Consultation Response from KC, Highways Development Management
2026/91969 land off, Fenay Lane, Almondbury, Huddersfield, HD5 8UJ
Erection of 6 dwellings, with associated access, landscaping, infrastructure and works
Date Responded: 11 August 2026 Responding Officer: Sheila Henley Responding Ref: K11-6SW/2

Recommendation: Further Details and Revisions.

Plan ref: (PL)123C - Hard Landscape; 26-255-EW07-P01 - Hard Surfacing; 26-255-EW03-P02 - Vehicle Tracking

Job No.	26-255	Scale @ A1	As Shown
Drawing No.	EW09		Revision P02

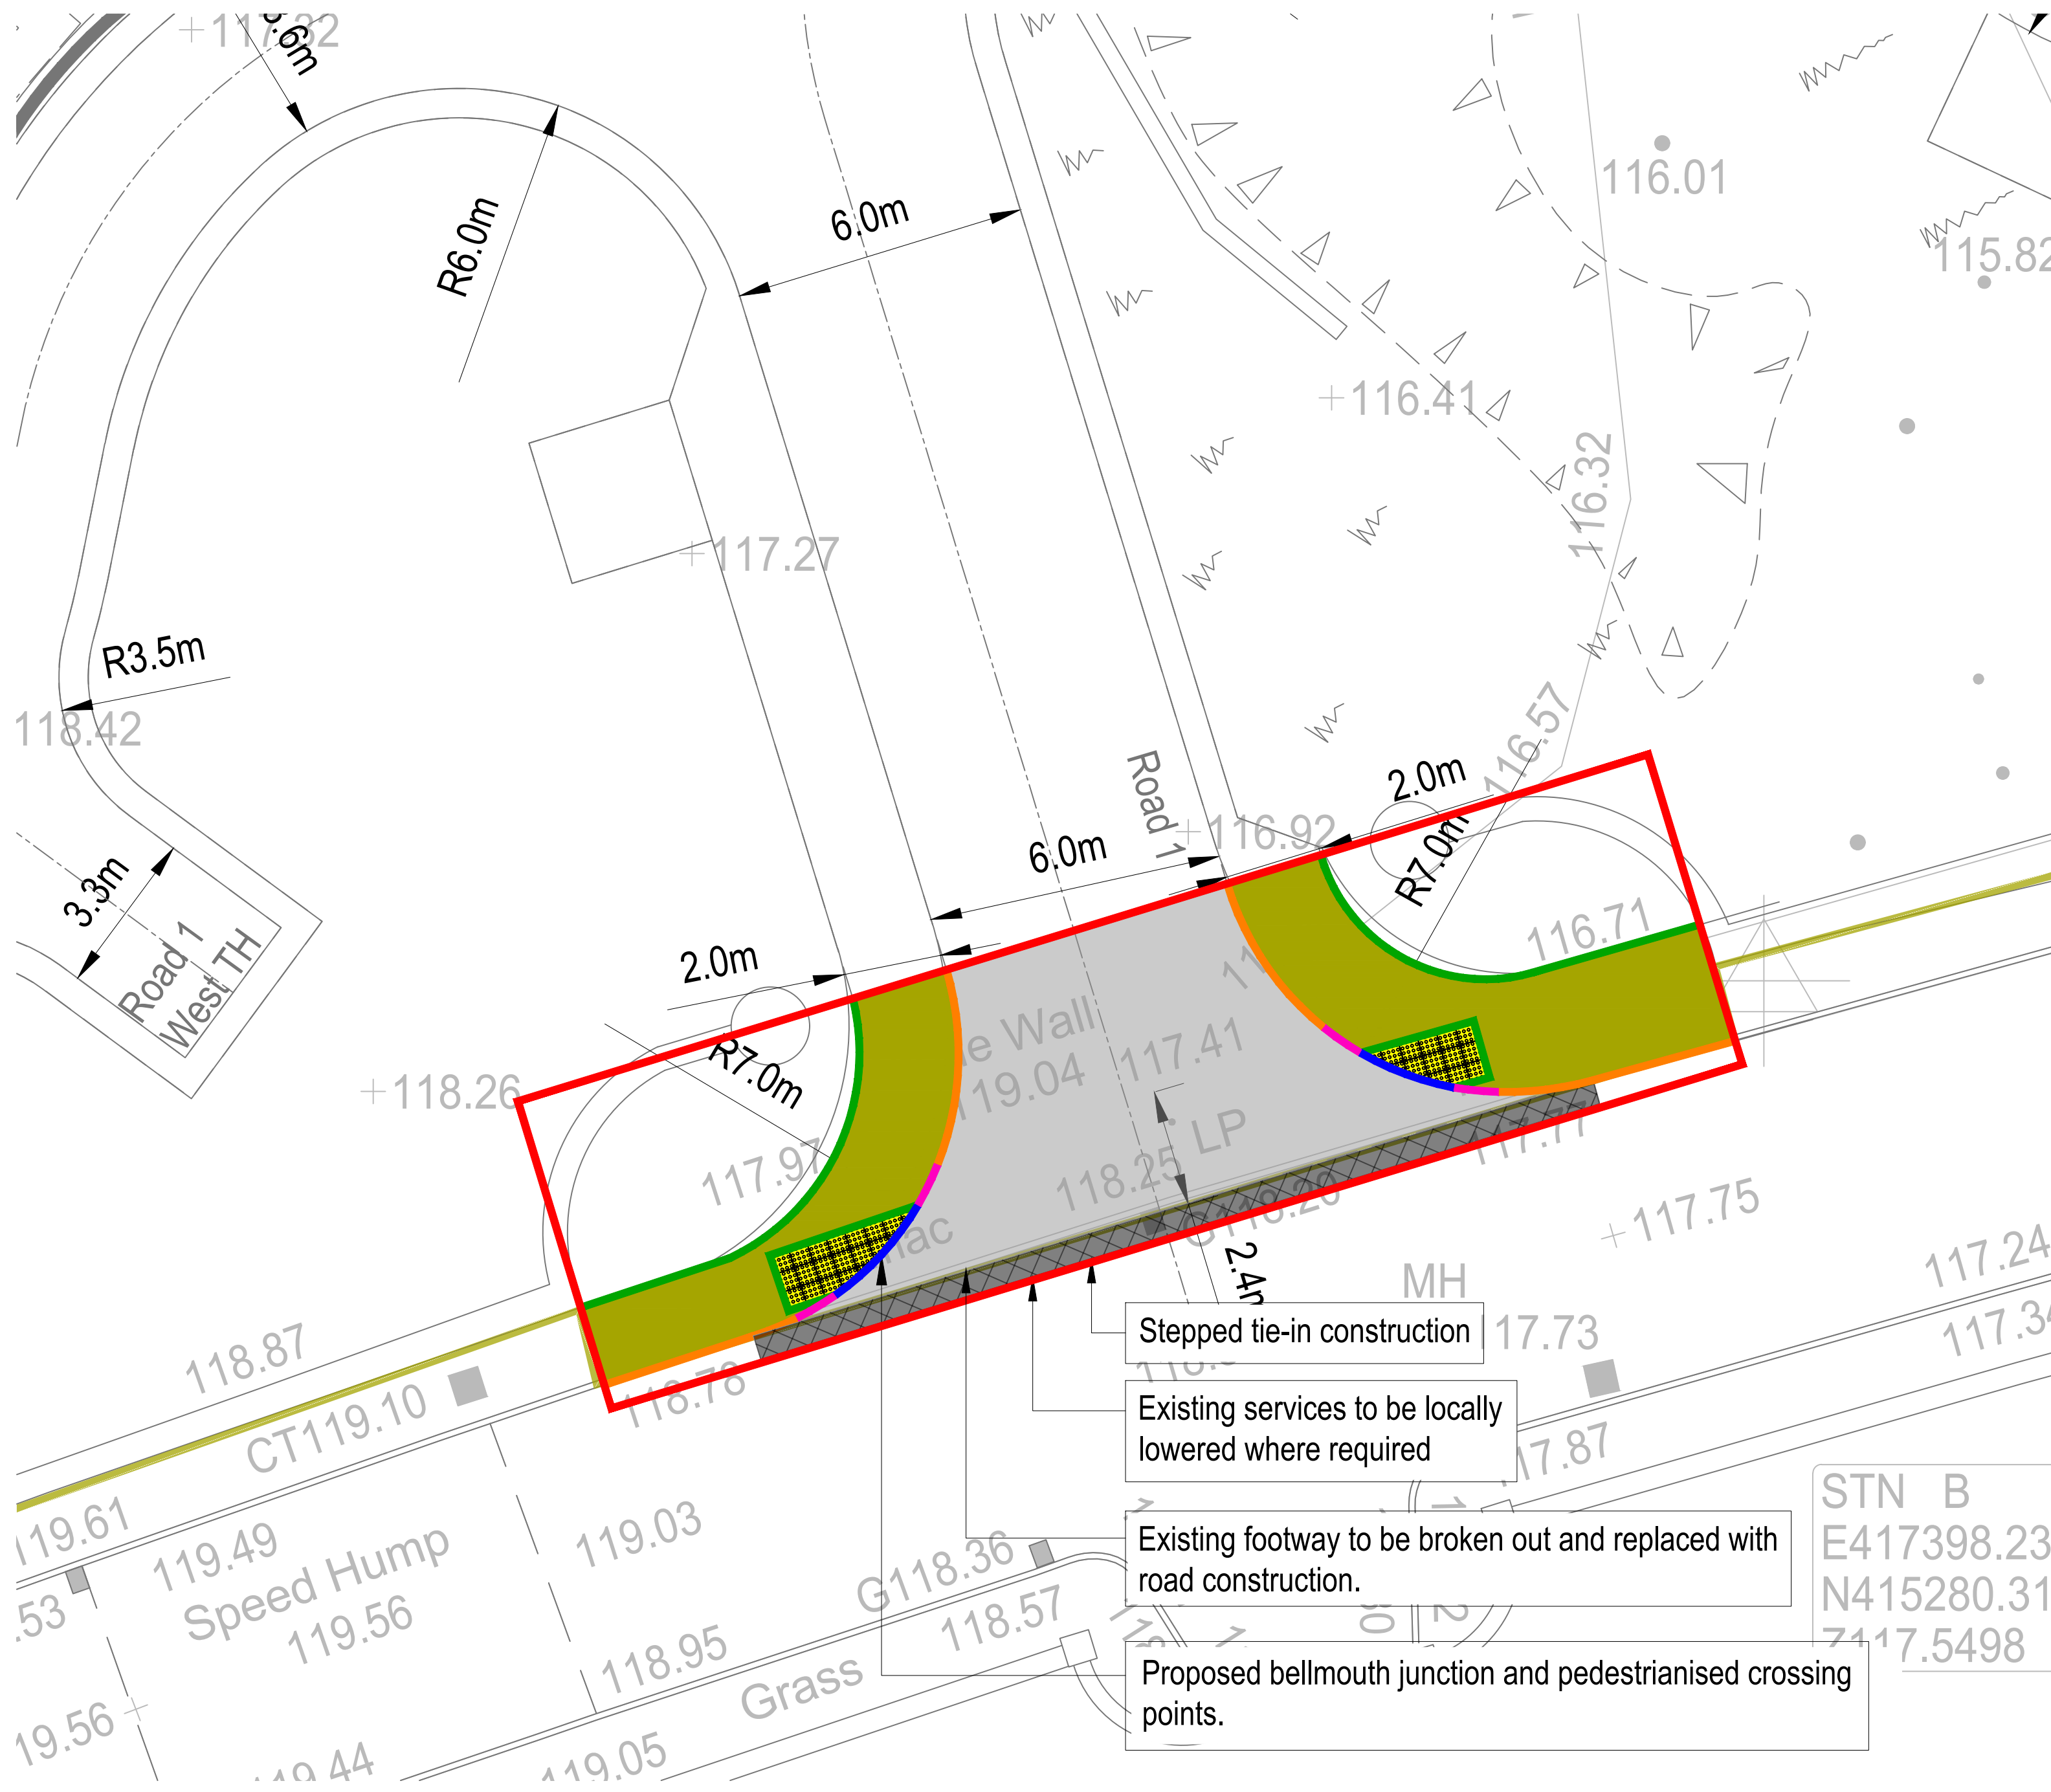
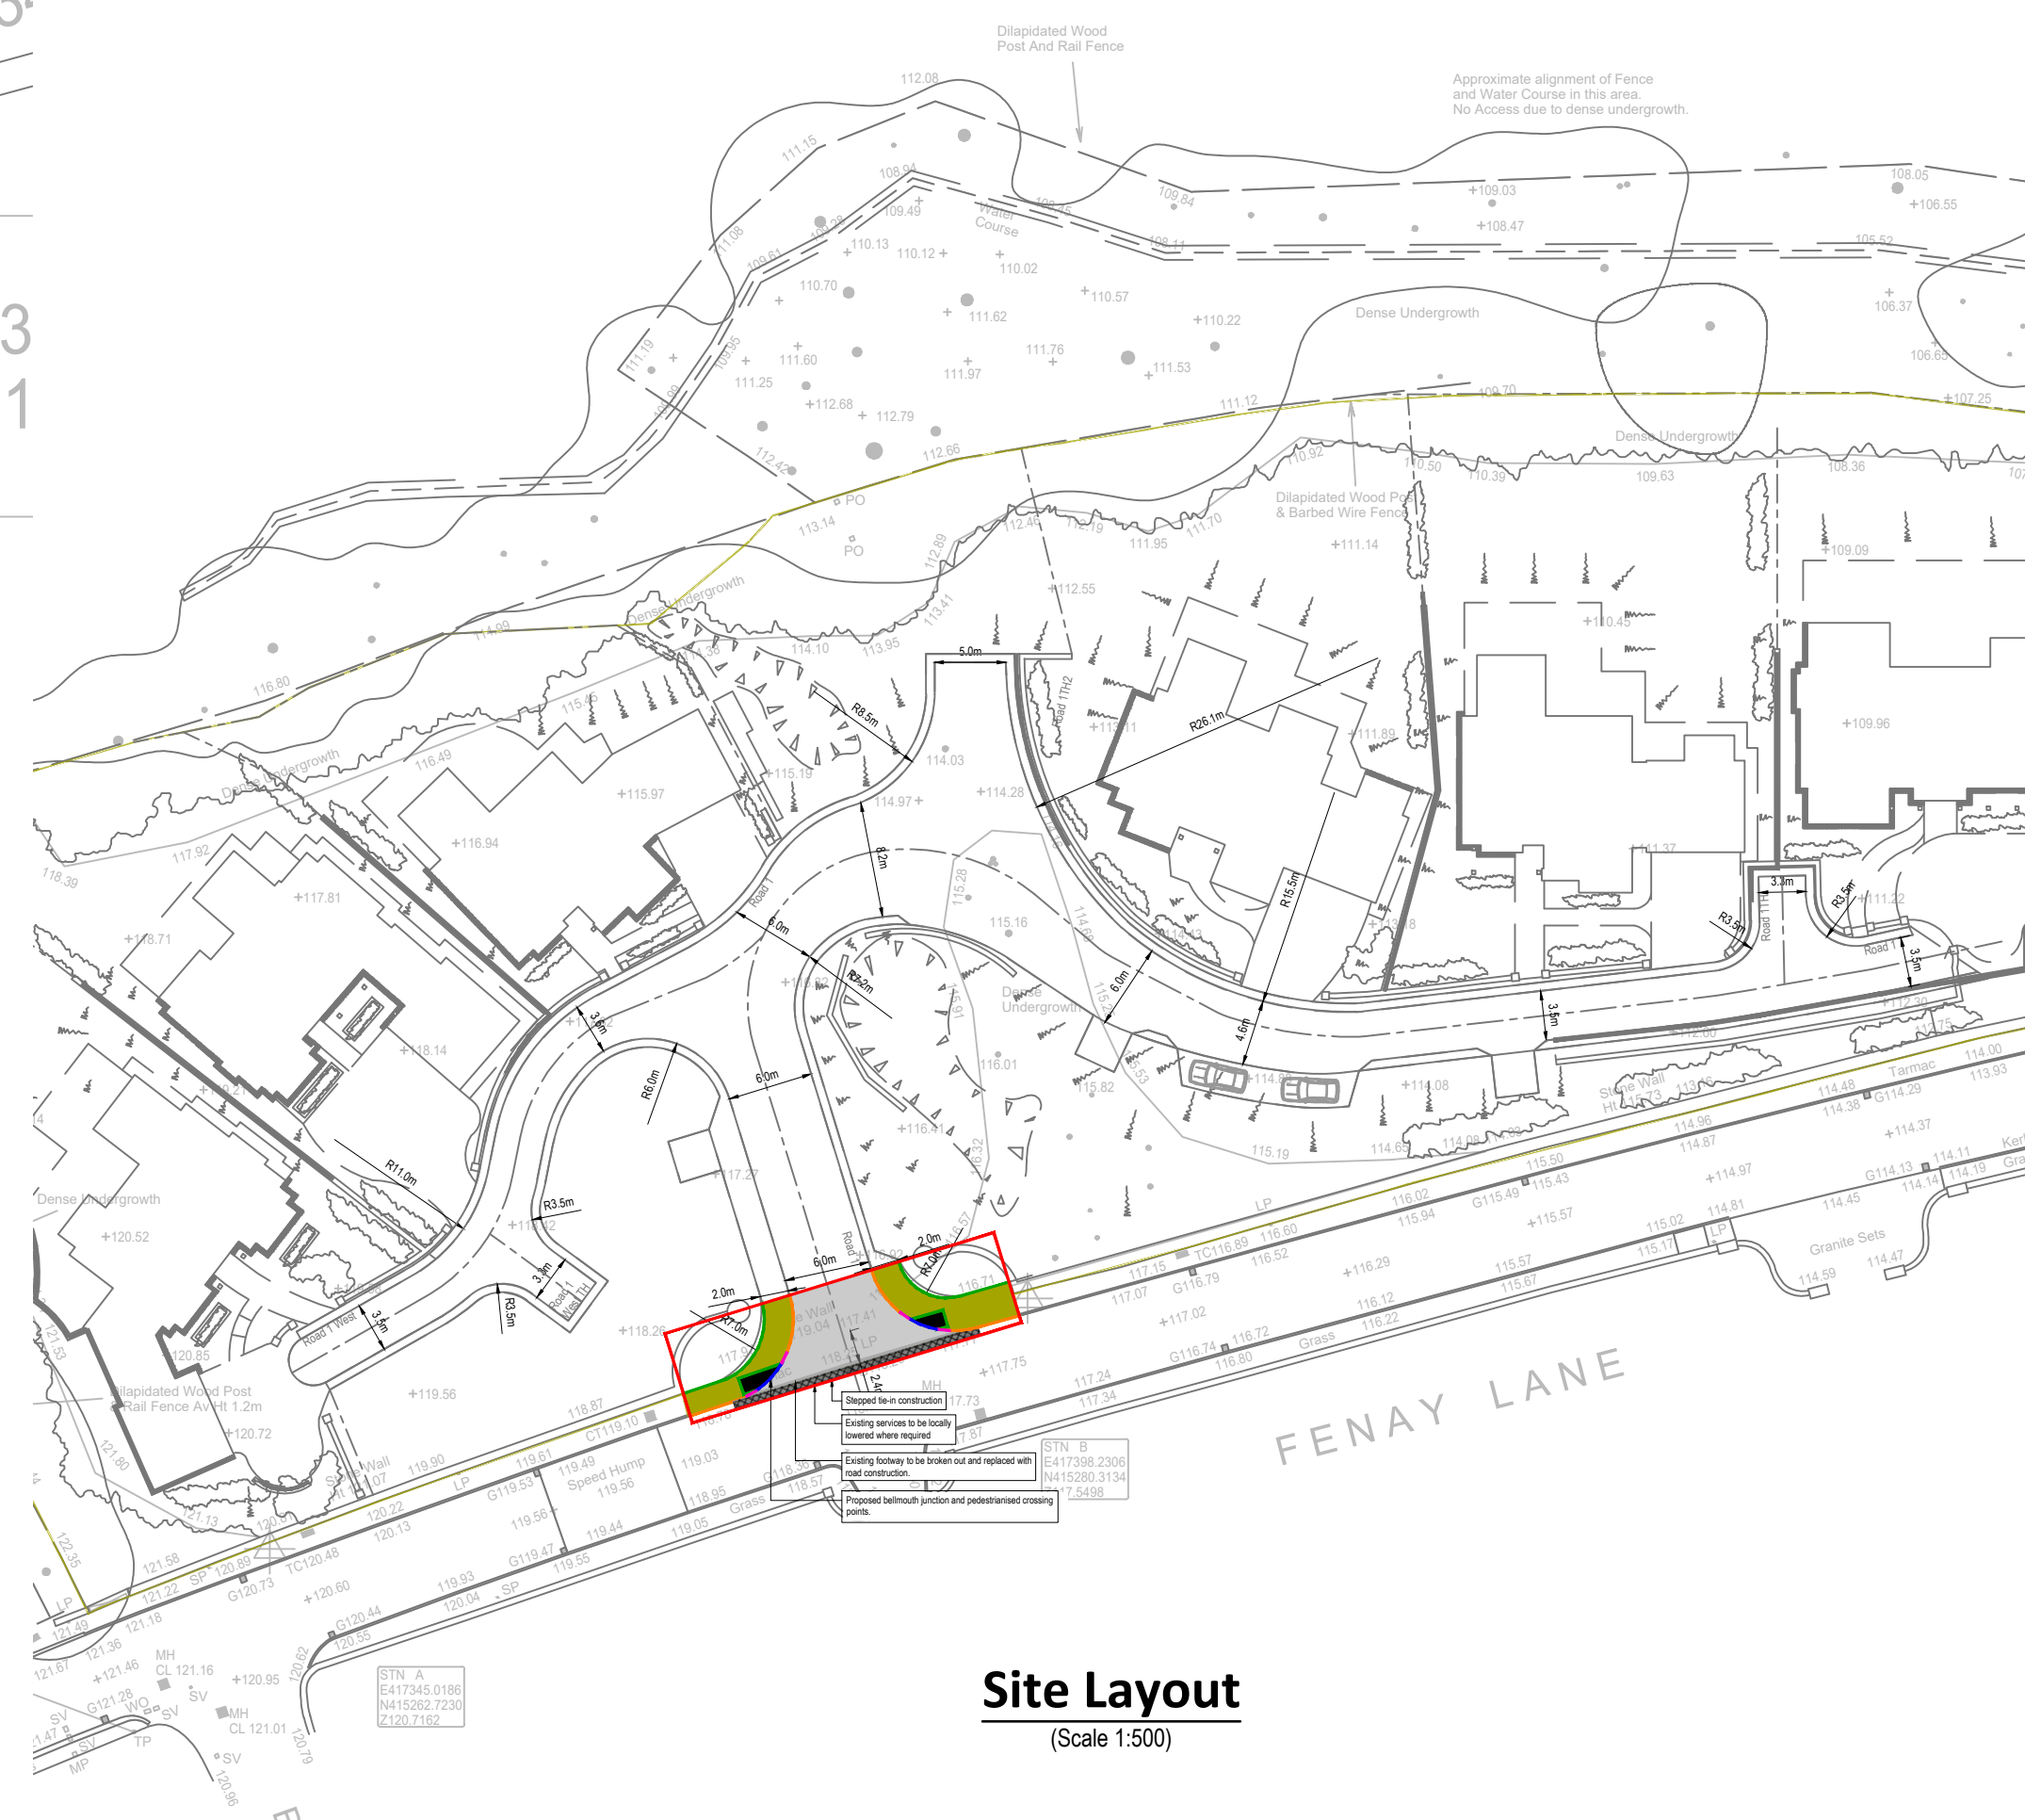
The junction will need to be amended to accord with the Kirklees specification as shown below despite the swept paths being mostly acceptable other than for the left turn out which is too tight to the kerb line and adjustment will be necessary.

There are no visibility splays indicated. Junction and Forward Visibility Splays and dimensions must be in accordance with the KHDG SPD Table 1 with junction visibility 2.4m x 25m (circled red) and forward visibility around the bends of 25 metres (circled blue). Junction visibility splays apply to the turning heads too if the extents of the carriageway are less than 25.0m. There must be no obstructions within these areas i.e. street furniture, parking bays, landscaping etc.

For waste collection, there is space for bin storage. The submitted swept path demonstrate that the vehicle can access and turn within the initial 'Y' section of the street. Yet, the bin pull distances to the collection points exceed 30m for the proposed dwellings at the extremes and should be reviewed and if necessary, the streets widened as circled below for the waste collection vehicle to reach these plots:

The road widths are quite narrow at the extremes for fire and rescue appliances too where typically 3.7m is the norm. It must be demonstrated by a swept path analysis to show that these vehicles can get within 45m of entrances.
